From: Chloe Dunlop
Sent: Wednesday, 14 February 2018 3:29 PM
To: 'Shivesh Singh'
Cc: 'Bradley Searle'; Kelly McNicol; Chris Ritchie
Subject: Comments on Bingo Minto RTS - SSD 7462
Attachments: SW Response 165523.pdf; Minto Resource Recovery Facility (SSD) 7462 application - RTS; 20180209 Findlay Consulting Engineers - Response to SSD 7462 amended Development Application.pdf; Letter Out - FRNSW Response to Submissio~- 13 Pembury Road Minto - Chloe Dunlop - Department of Planning and Environment.pdf; L&W response - Minto Resource Recovery Facility - RTS.PDF; Invoice for Additional Application Fee -Bingo Minto SSD 7462.pdf

Thank you for coming in to our office recently to discuss the Minto application. Please find **attached** comments from the following agencies regarding the December 2017 RTS:

TITLE
25.0m B-DOUBLE - SWEEP PATH

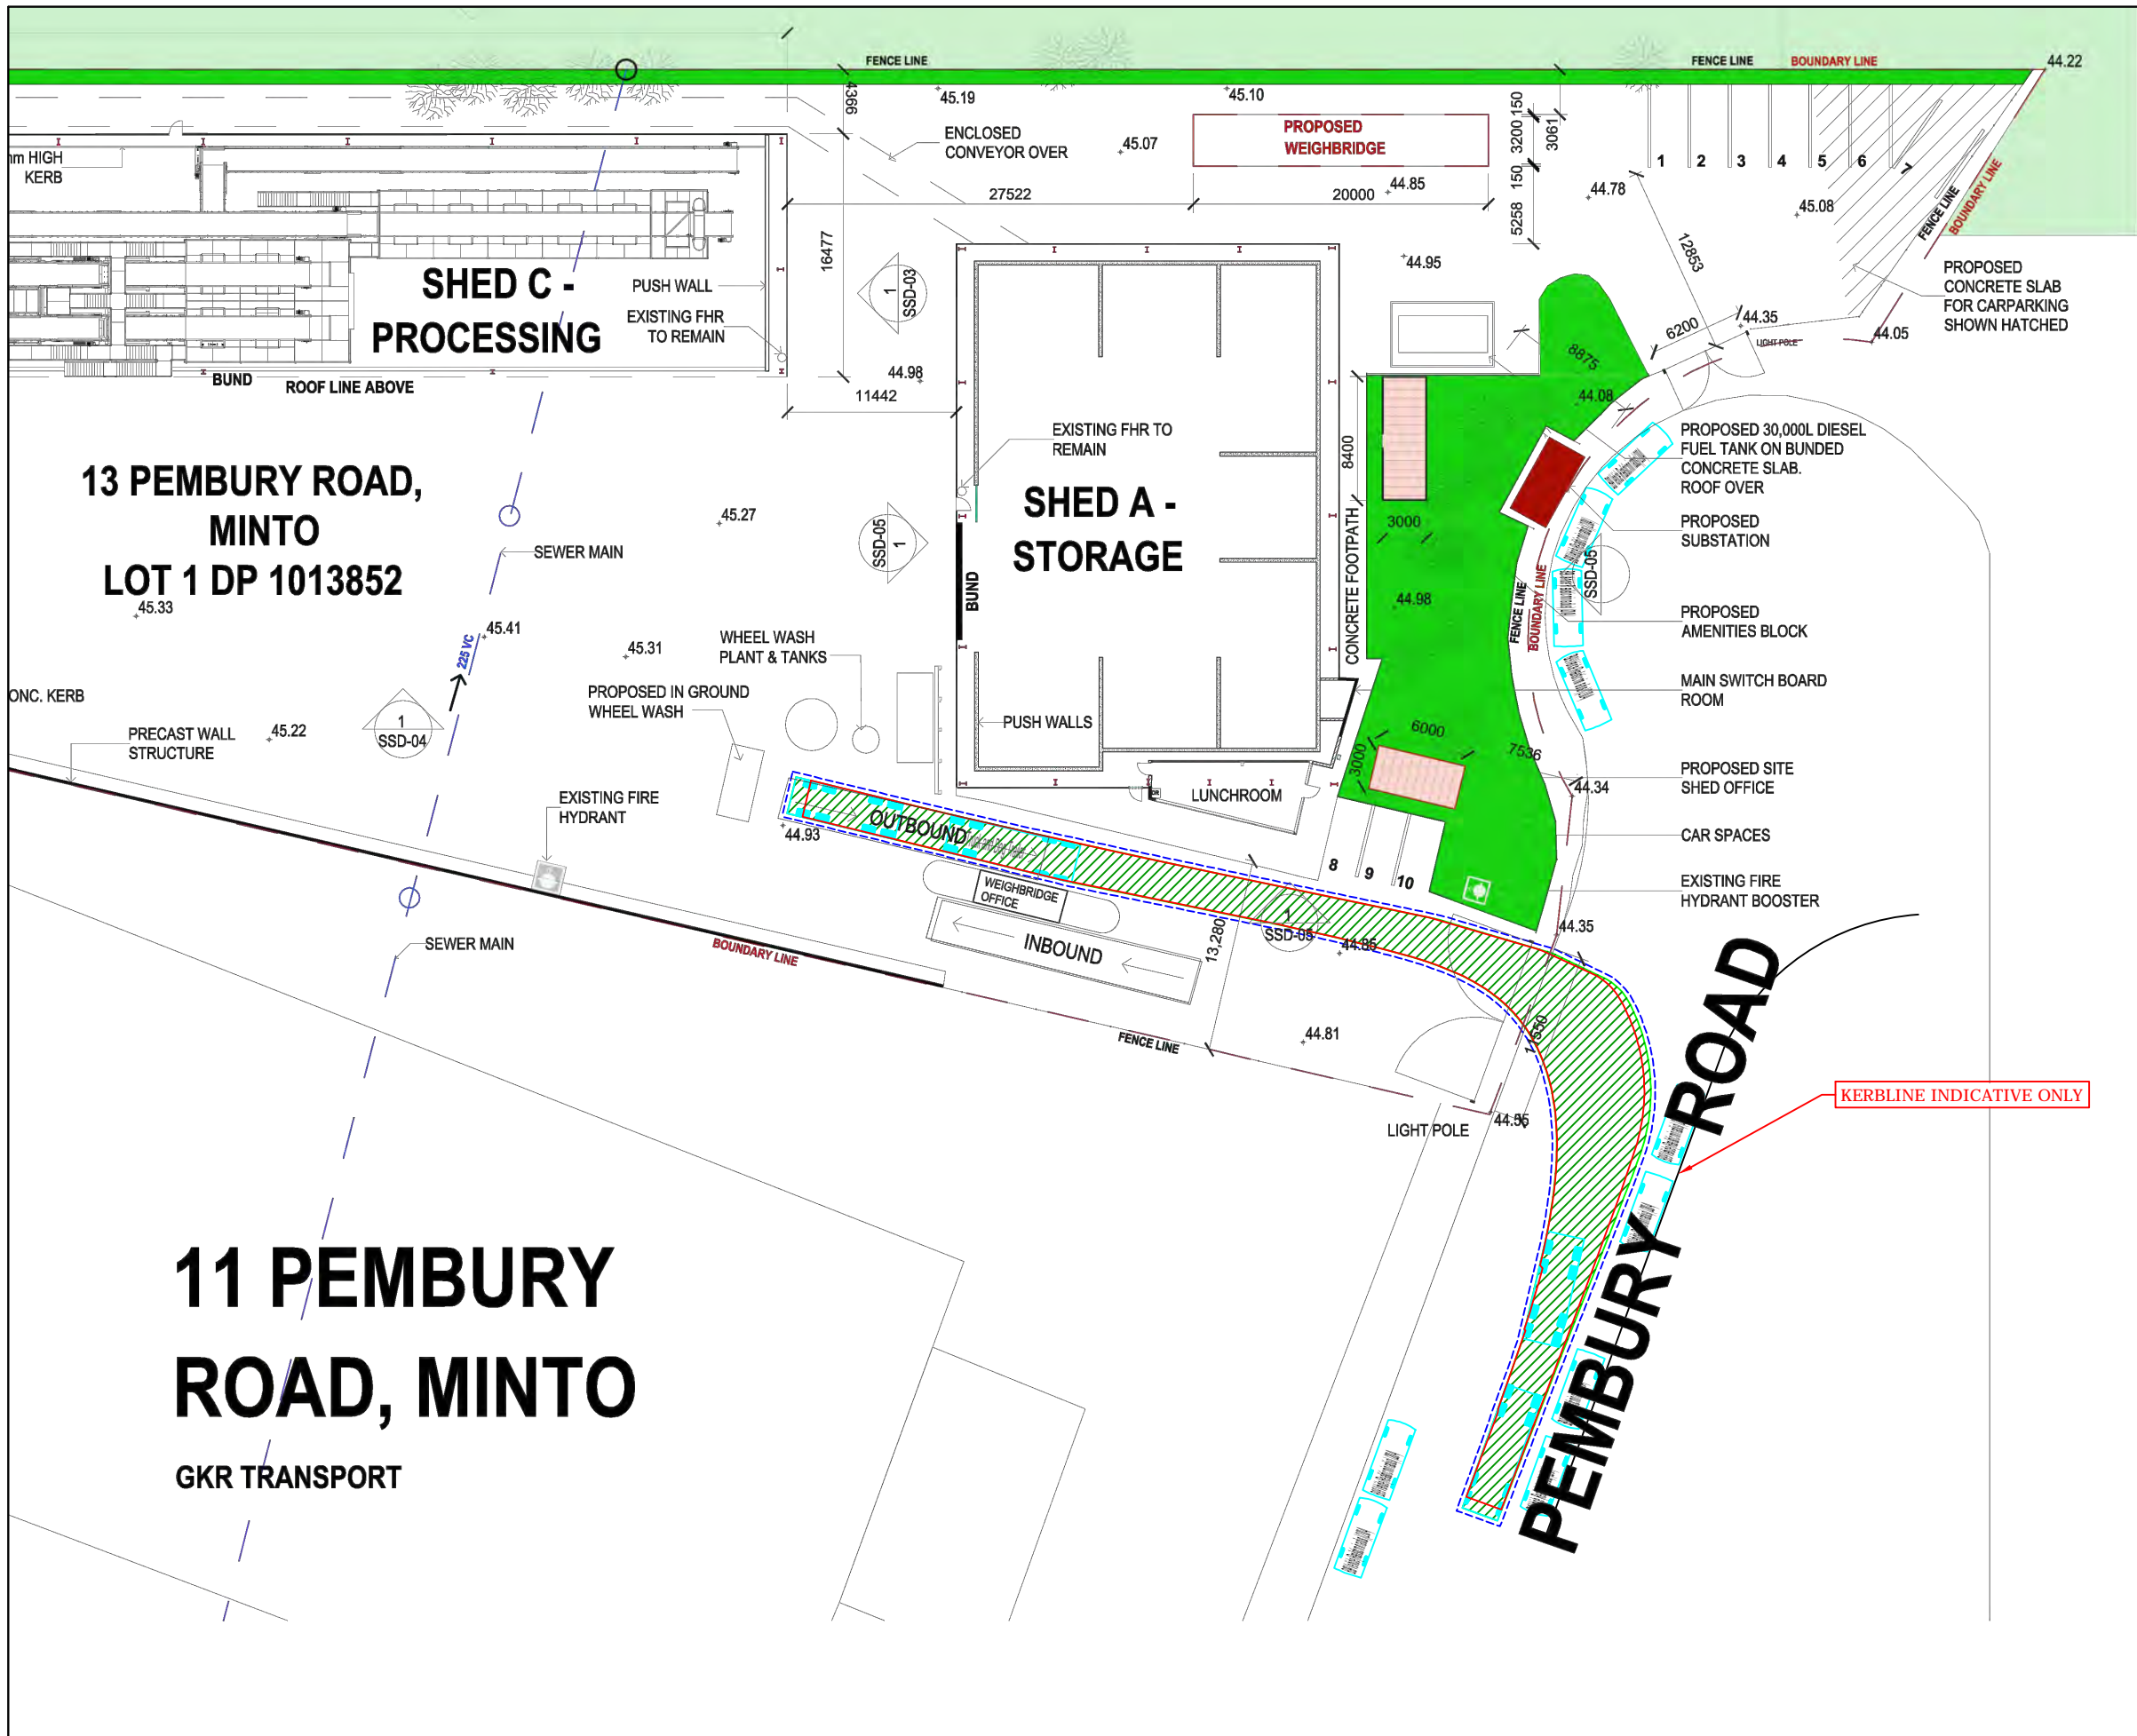
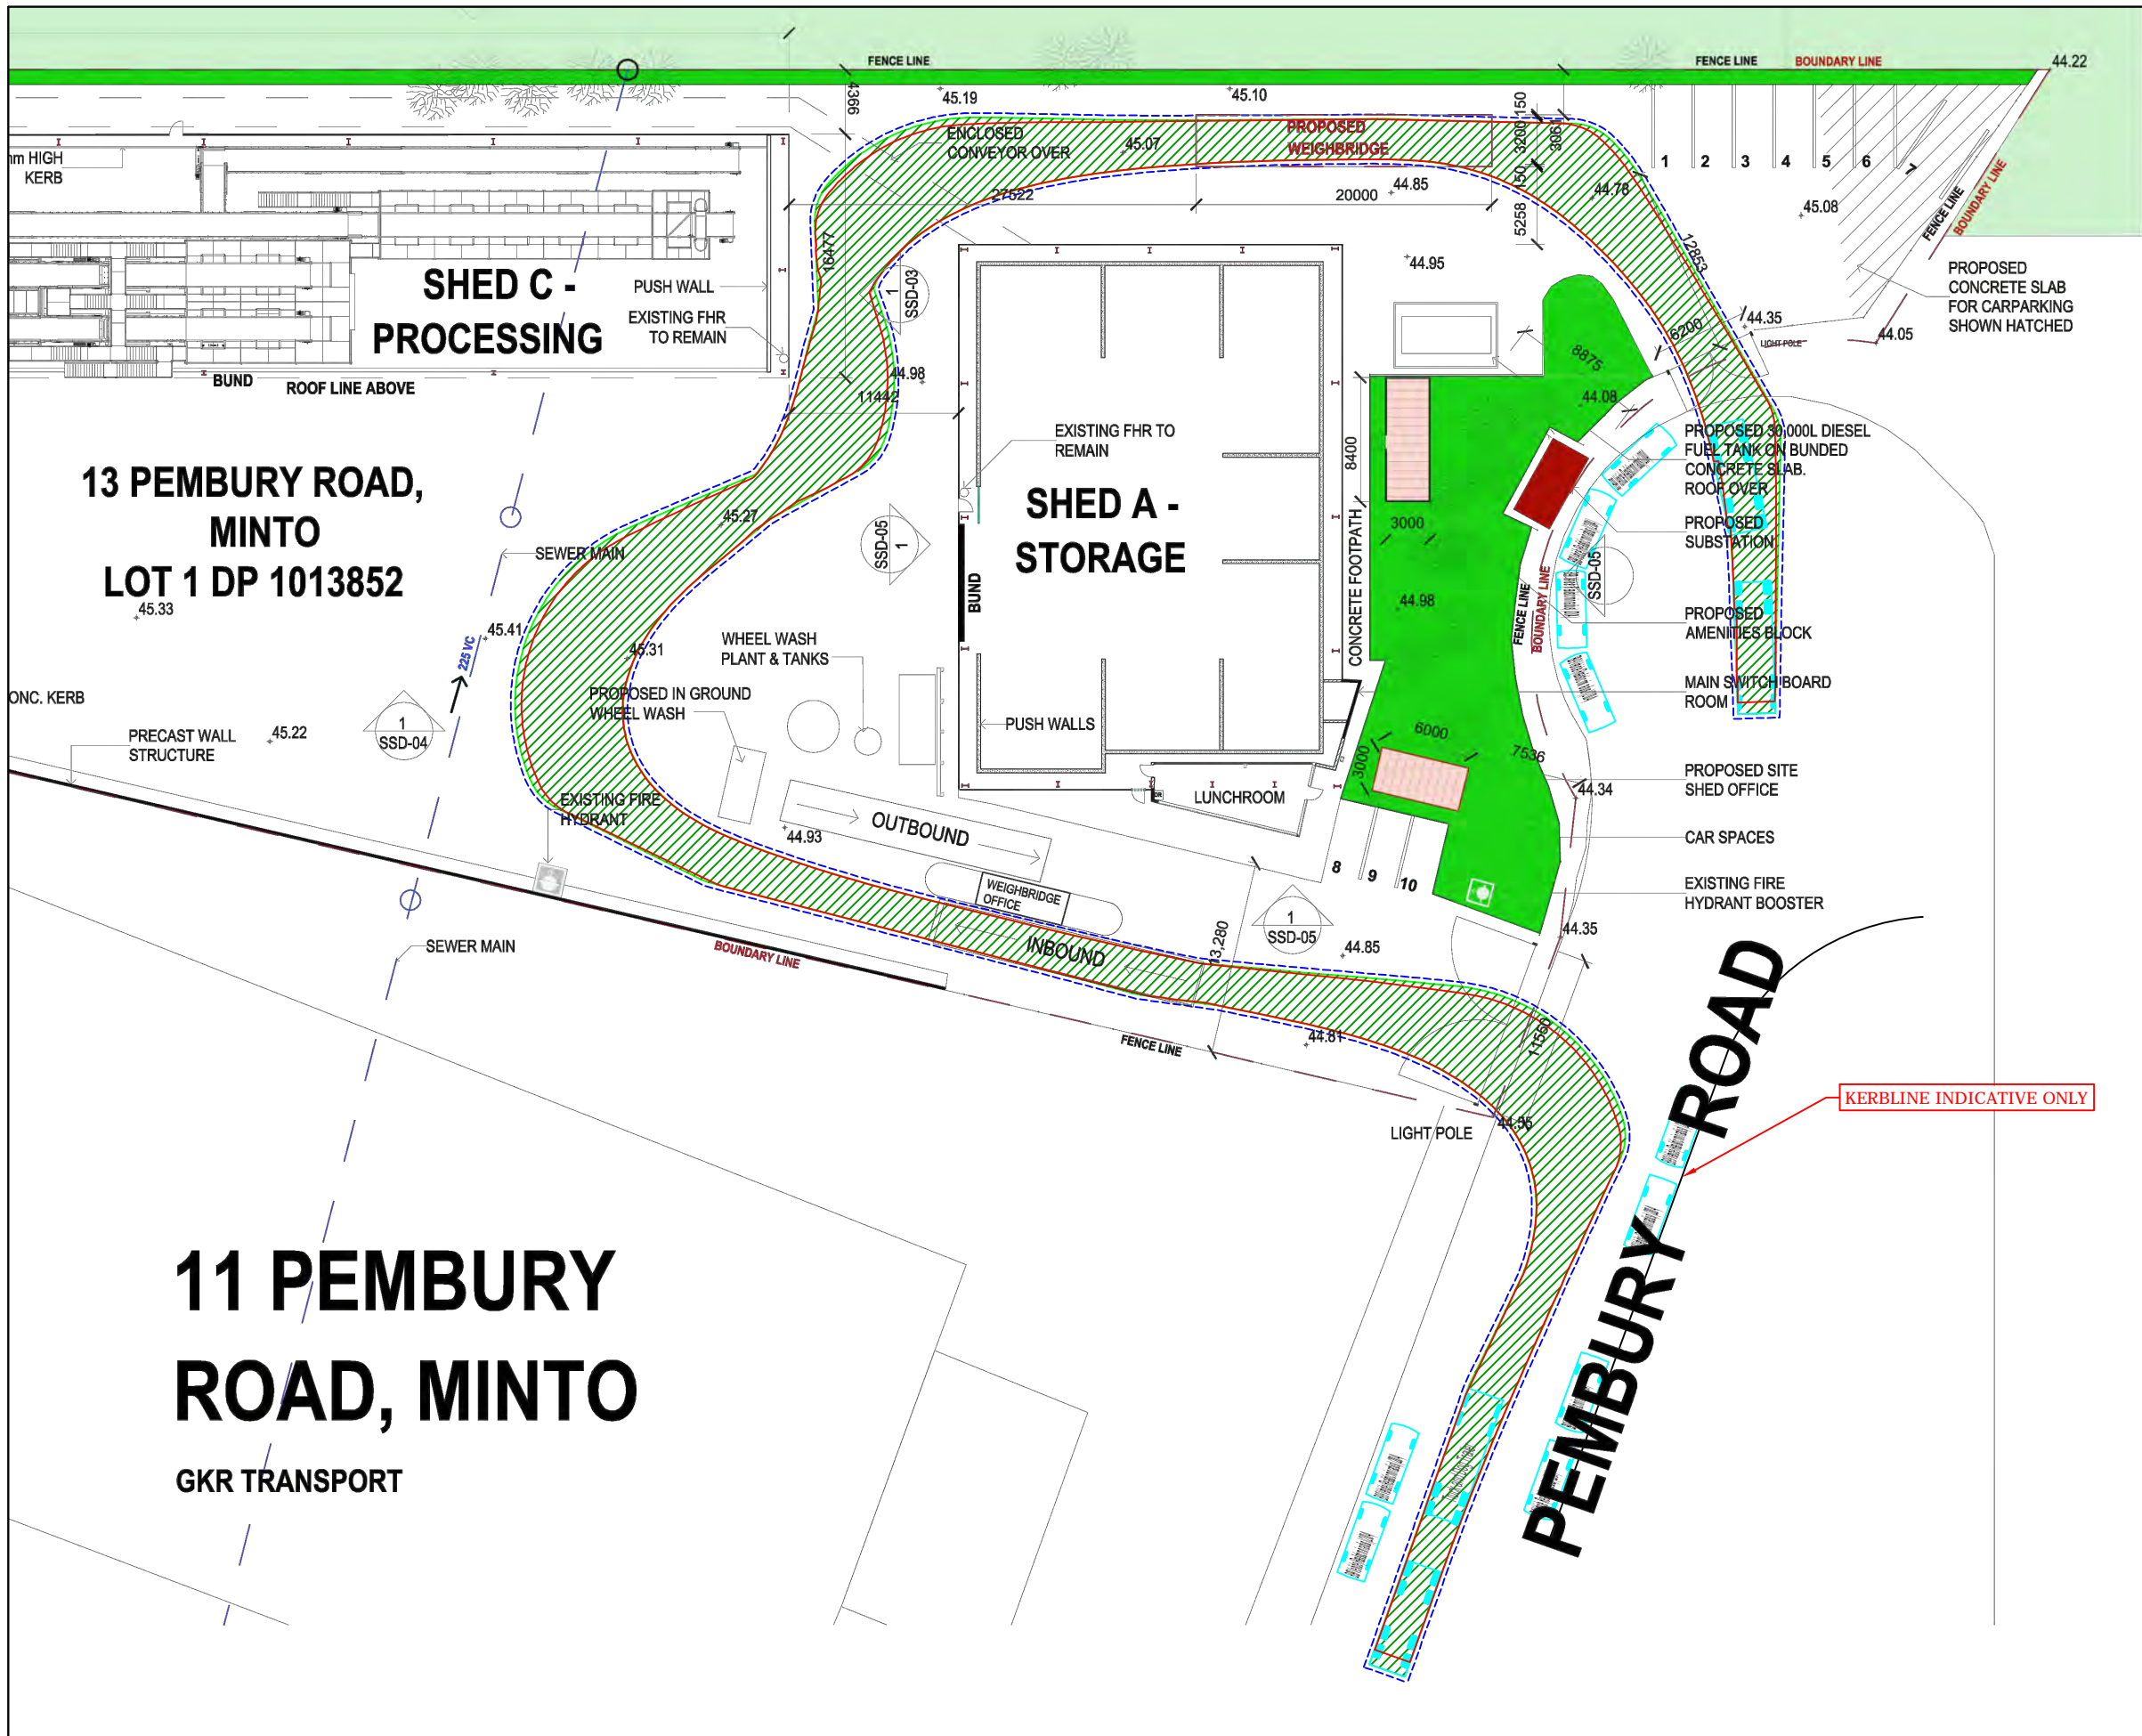
7. At our meeting of 24 January, the Department expressed concern that the swept path diagrams for waste collection trucks will be too tight. Consideration should be given to scheduling waste collection by 25 metre trucks to outside of the early morning peak unloading period to avoid conflicts with other vehicles on-site and the potential for vehicles queuing on Pembroke Road.
